Planning Application No: 3/2024/0267

Proposal: Proposed two-storey side extension, new pitched roof over existing side extension, single-storey rear extension and alterations to veranda, new front porch and new peak roof at front.

Location: Fair View, Pendleton Road, Wiswell BB7 9BU

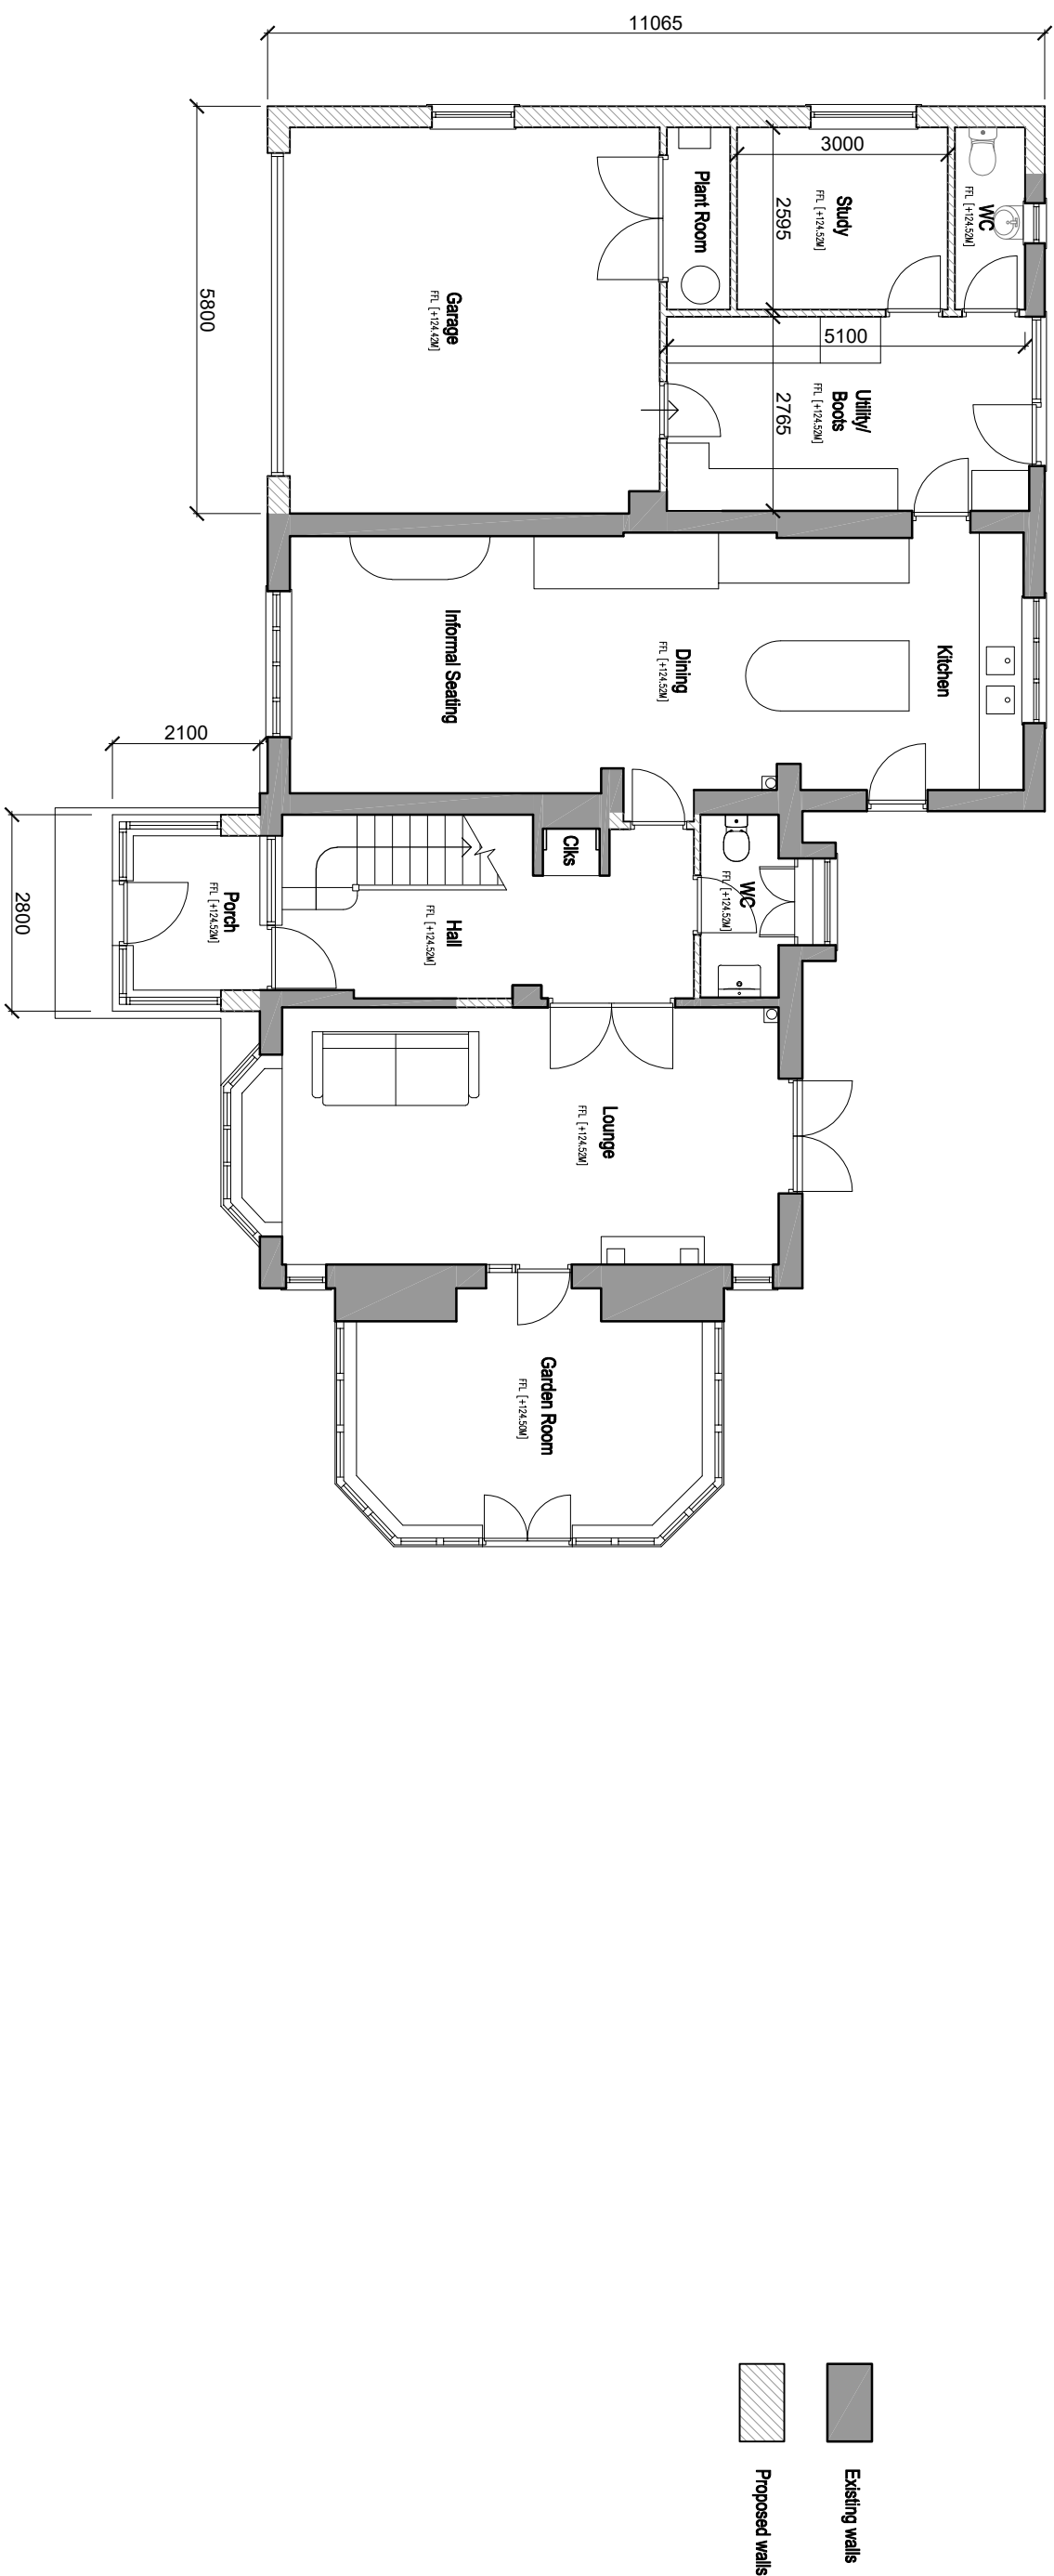
The proposed integral garage is adequately sized internally to provide one car parking space, together with secure cycle storage. Two further parking spaces can be

accommodated on the existing driveway/hardstanding and should still allow vehicles to enter and leave the site in forward gear.

Due to the limited internal manoeuvring area this shall be kept free from obstructions, eg pots, planters etc, for the lifetime of the development to ensure that vehicles can enter and leave the site in forward gear, as vehicles reversing onto the highway pose a hazard to other highway users.

1. Prior to first occupation of the approved development an electric vehicle charging point shall be provided. Charge points must have a minimum power rating output of 7kW and be fitted with a universal socket that can charge all types of electric vehicle currently available. Reason: To ensure that the development provides the infrastructure for sustainable forms of transport.
2. Prior to first occupation of the approved development the parking and manoeuvring areas shown on the approved plans shall be provided and thereafter always remain available for the parking of vehicles associated with the dwelling and the manoeuvring areas shall be kept free from obstructions in perpetuity. Reason: To ensure that satisfactory levels of parking and manoeuvring are provided within the site.
